Recommendation Report for Lawful Development Certificate for a Proposed Use or Development**REF NO:** **AW/140/22/CLP****LOCATION:** 15 Bradlond Close
 Aldwick
 PO21 2RQ**PROPOSAL:** Lawful development certificate for a proposed single storey rear extension.**DESCRIPTION OF APPLICATION**

Drawing Title
Proposed Plans and Elevations

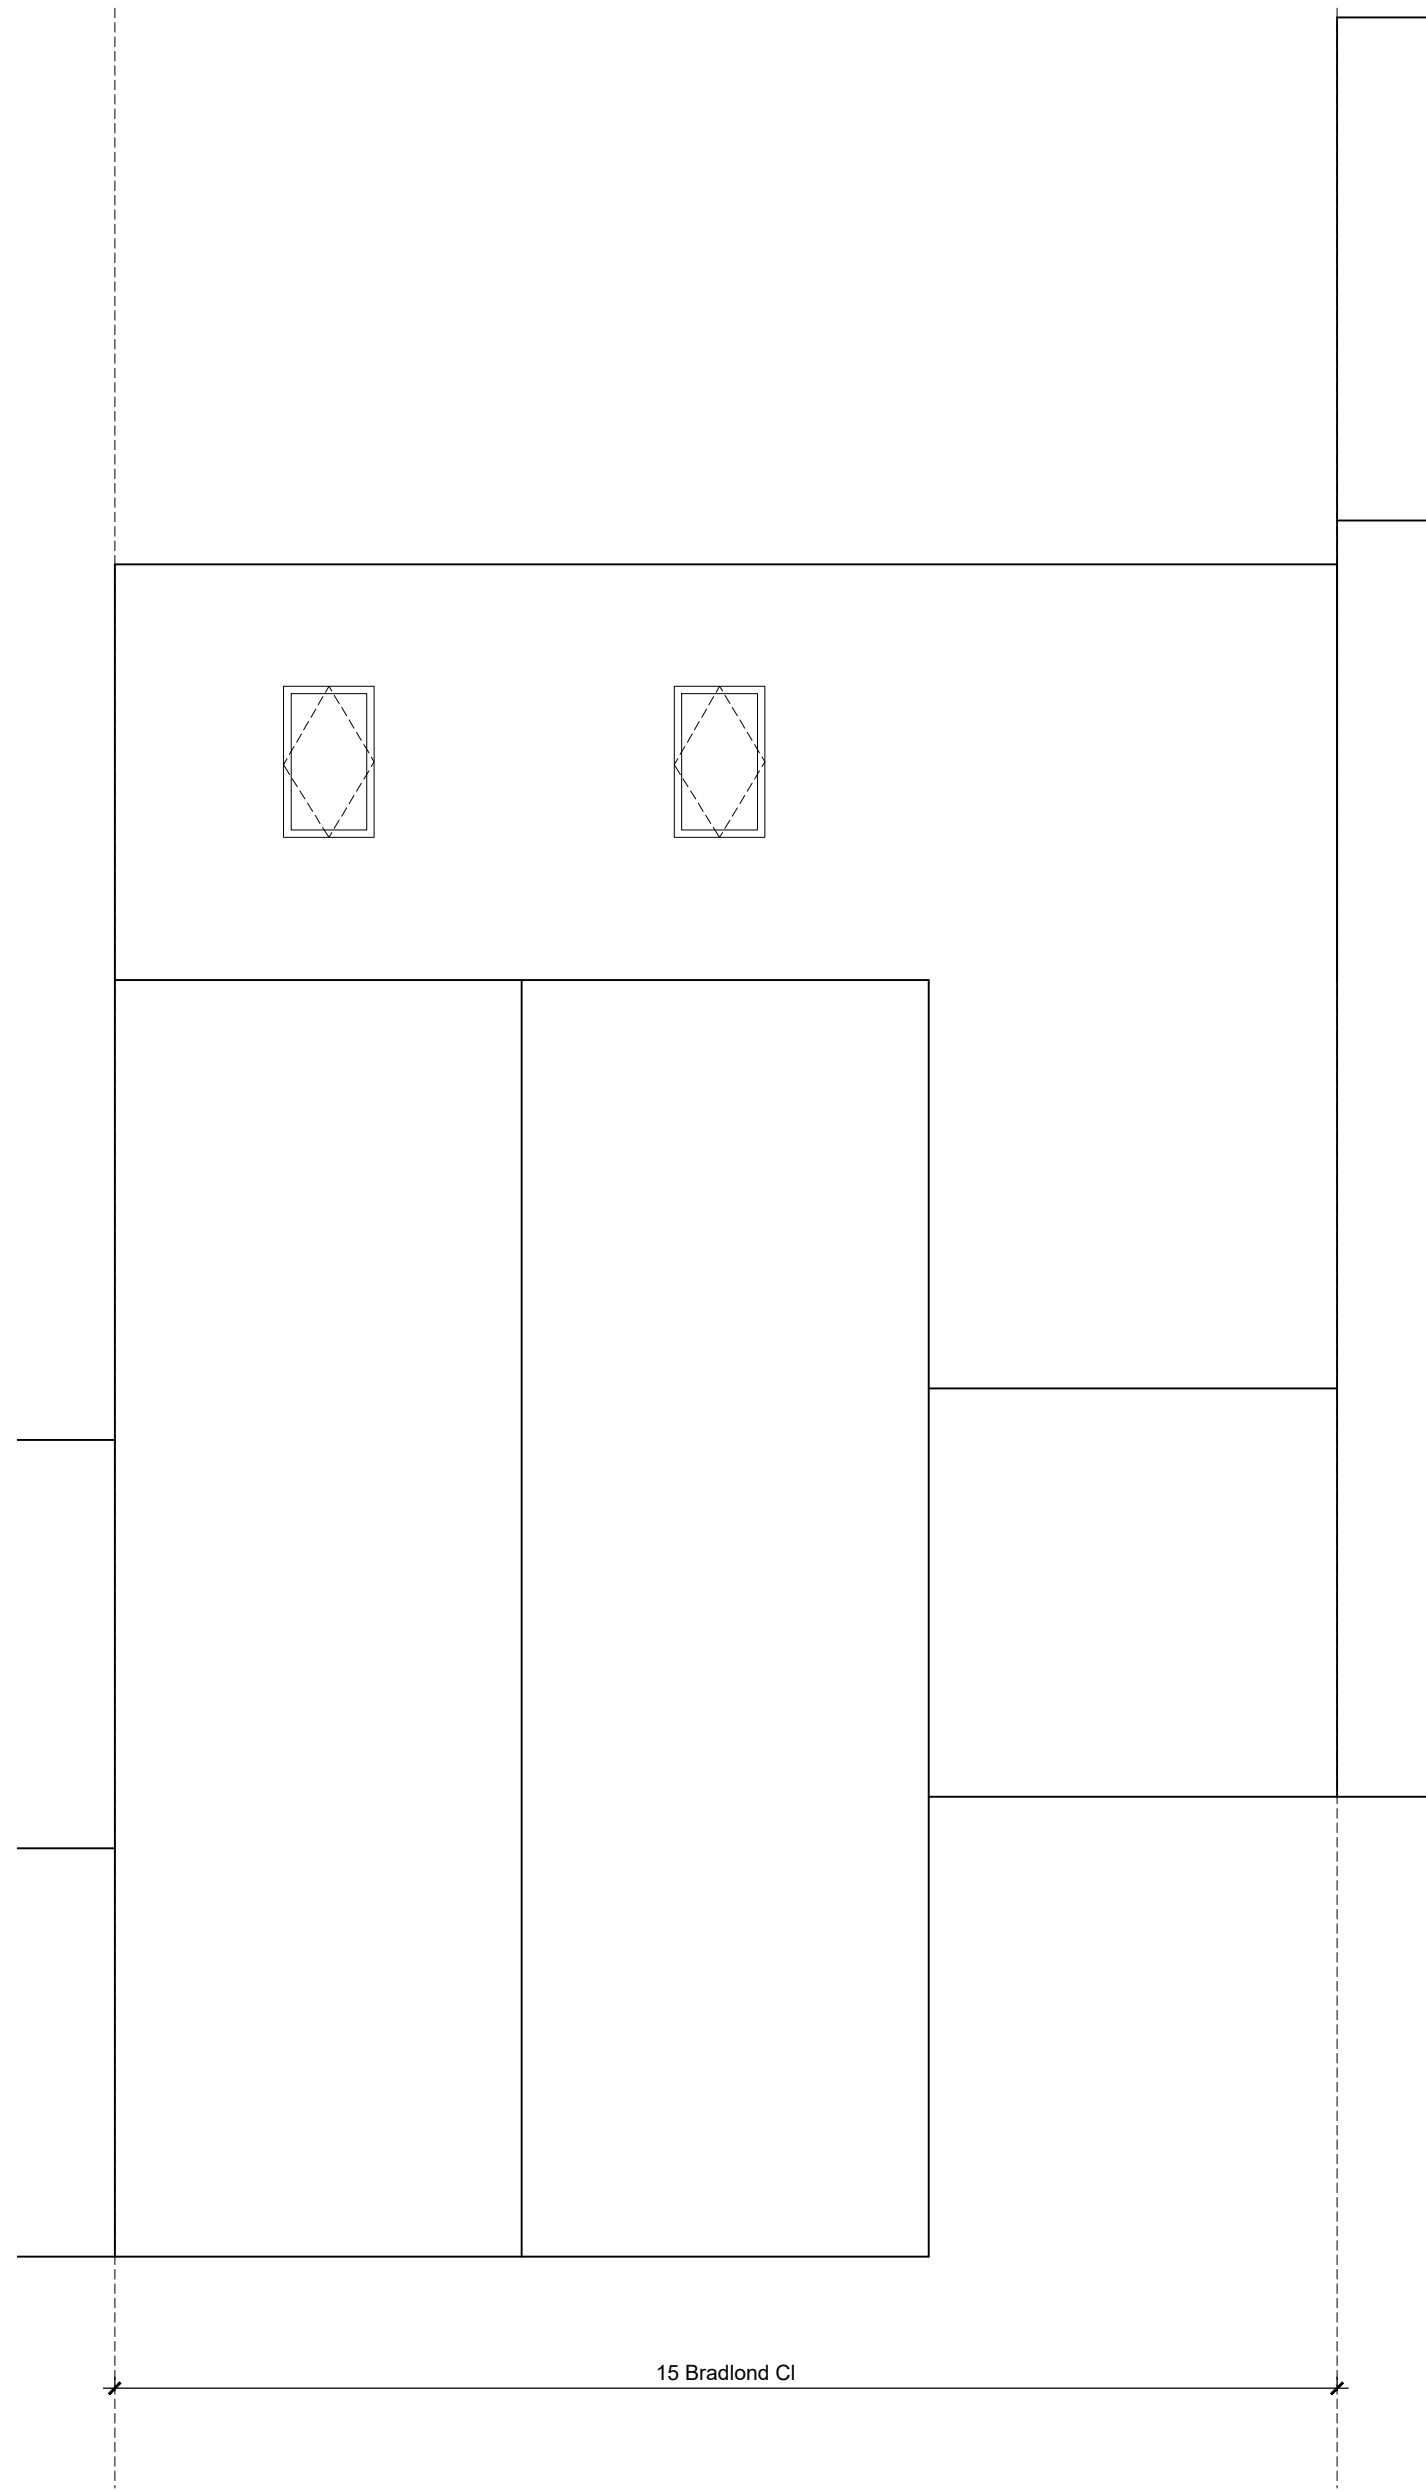
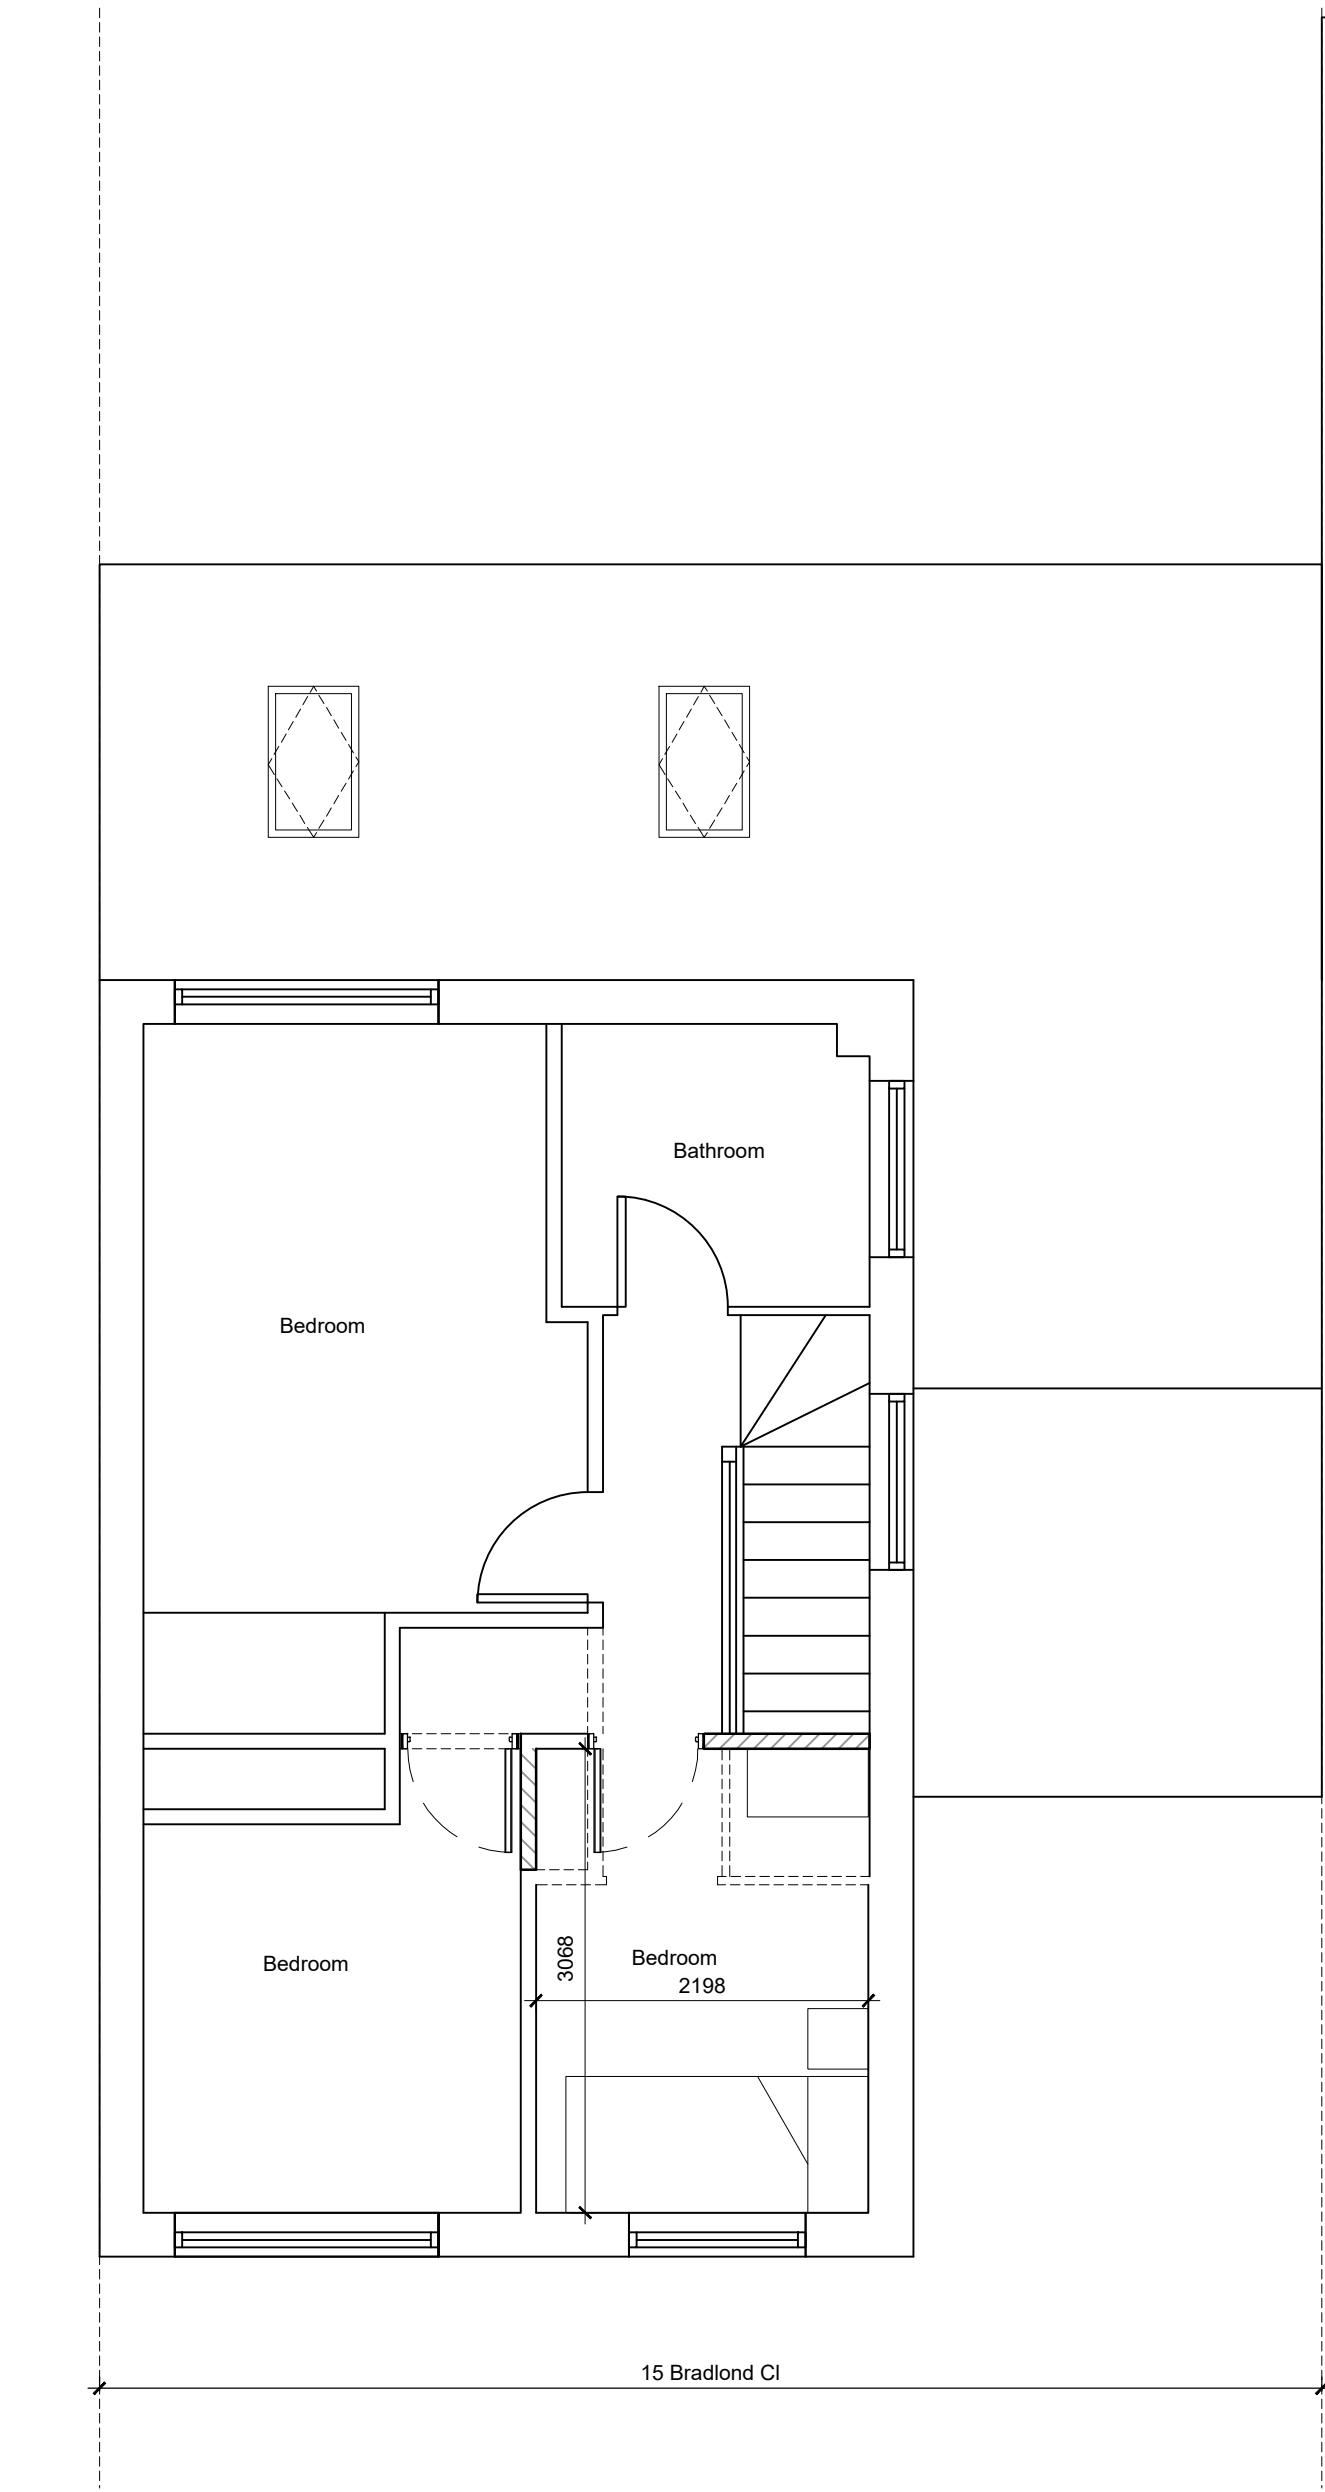
This application seeks a single storey rear extension measuring 2.75m deep and 8m wide, with a pitched lean to roof with eaves 2.6m high and a maximum height of 3.6m. It seeks to regrade one side of the garage roof in order to join with the proposed extension. The regraded roof will join from the extension to the ridgeline of the existing garage roof and retain a maximum height of 4.6m.

The property known as 15 Bradlond Close is a terraced property and is not listed or within a conservation area. The proposed extension and alterations would be of materials to match that of the existing.

The extension complies with relevant sections of Class A and is permitted development. The regrading of the roof complies with relevant sections of Class B and is permitted development. As such the development does not require the submission of an application for full planning permission.
